COUNTY COUNCIL'S RESPONSE TO CONSULTATION ON THE FOLLOWING DEVELOPMENT PROPOSAL

Application No: 18/00584/REM

Proposal: Reserved matters application to 15/01012/OUT - Development of up to 48,308sqm of employment floorspace (Class B1c, B2, B8 and ancillary B1a uses), the siting of buildings to the south of the site, servicing and circulation areas, vehicular and pedestrian access from Skimmingdish Lane and landscaping

Location: Land North East Of Skimmingdish Lane Launton

01 PROPOSED CYCLE SHELTER TO ACCOMODATE 12No. CYCLES
1018 Broxap Apollo - Colour Ral 7016 (Anthracite Grey)

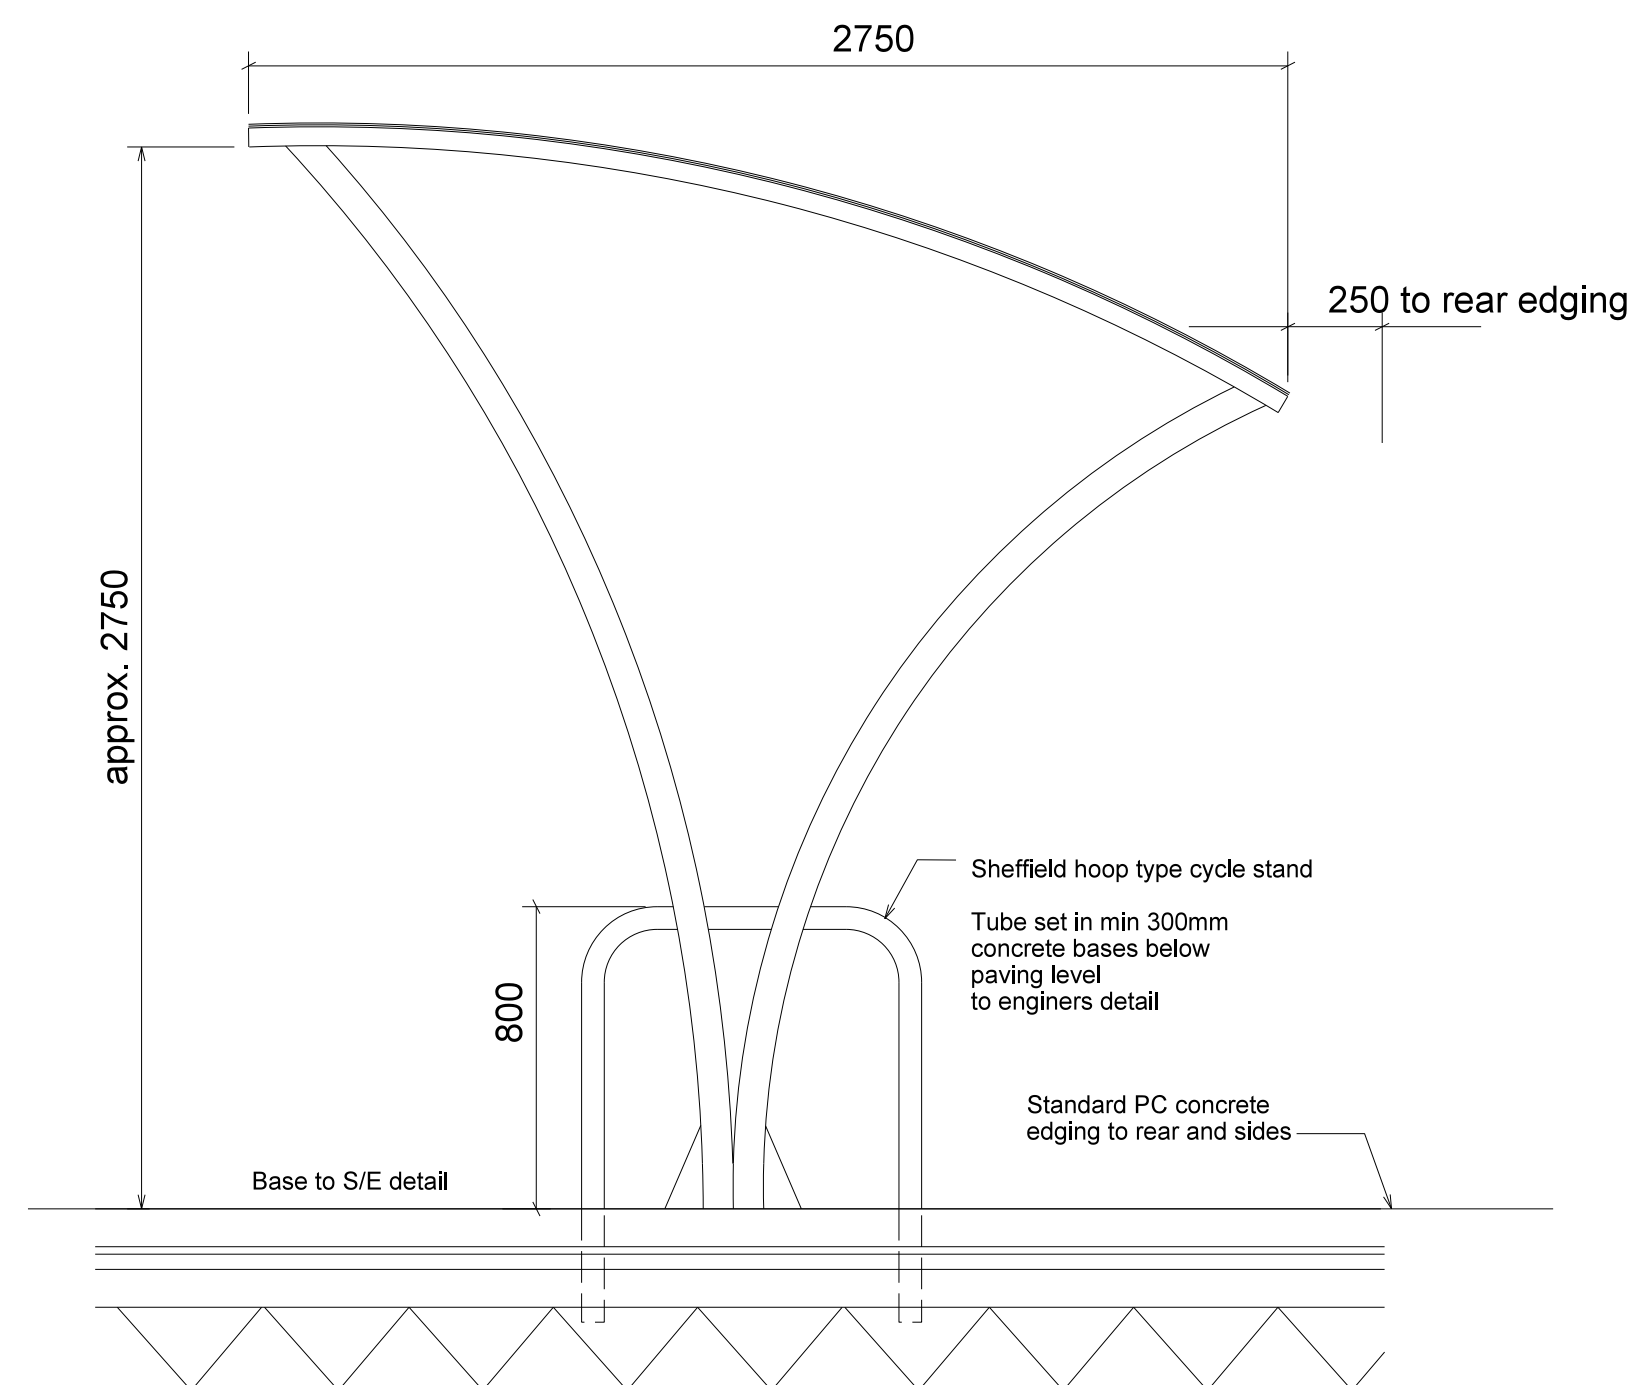
Notwithstanding the details shown on drawing number 17007 / TP / 1018 (Cycle Shelter Details) and prior to the first occupation of the development hereby approved, full details of the covered cycle parking facilities to be provided on the site shall be submitted to and approved in writing by the Local Planning Authority. Thereafter, the covered cycle parking facilities shall be provided, permanently retained and maintained for the parking of cycles in connection with the development in accordance with the approved details.

There is some inconsistency in the information relating to cycle parking provision. The Proposed Site Plan (Drg. No. 17007 / TP / 1003) and other drawings label 24no. cycles for each unit, as stated in 3.15 of the Reserved Matters Report. However, the Parking Note in Appendix 2 of the same Report states that there will be 24 **hoops** per unit, i.e. storage for 48 cycles per unit.

Considering the relative floor areas of the plots, it is concluded that the minimum storage must be at least that as defined in the Parking Note, i.e. 24 stands (48 spaces) for each Unit 1A and 1B.
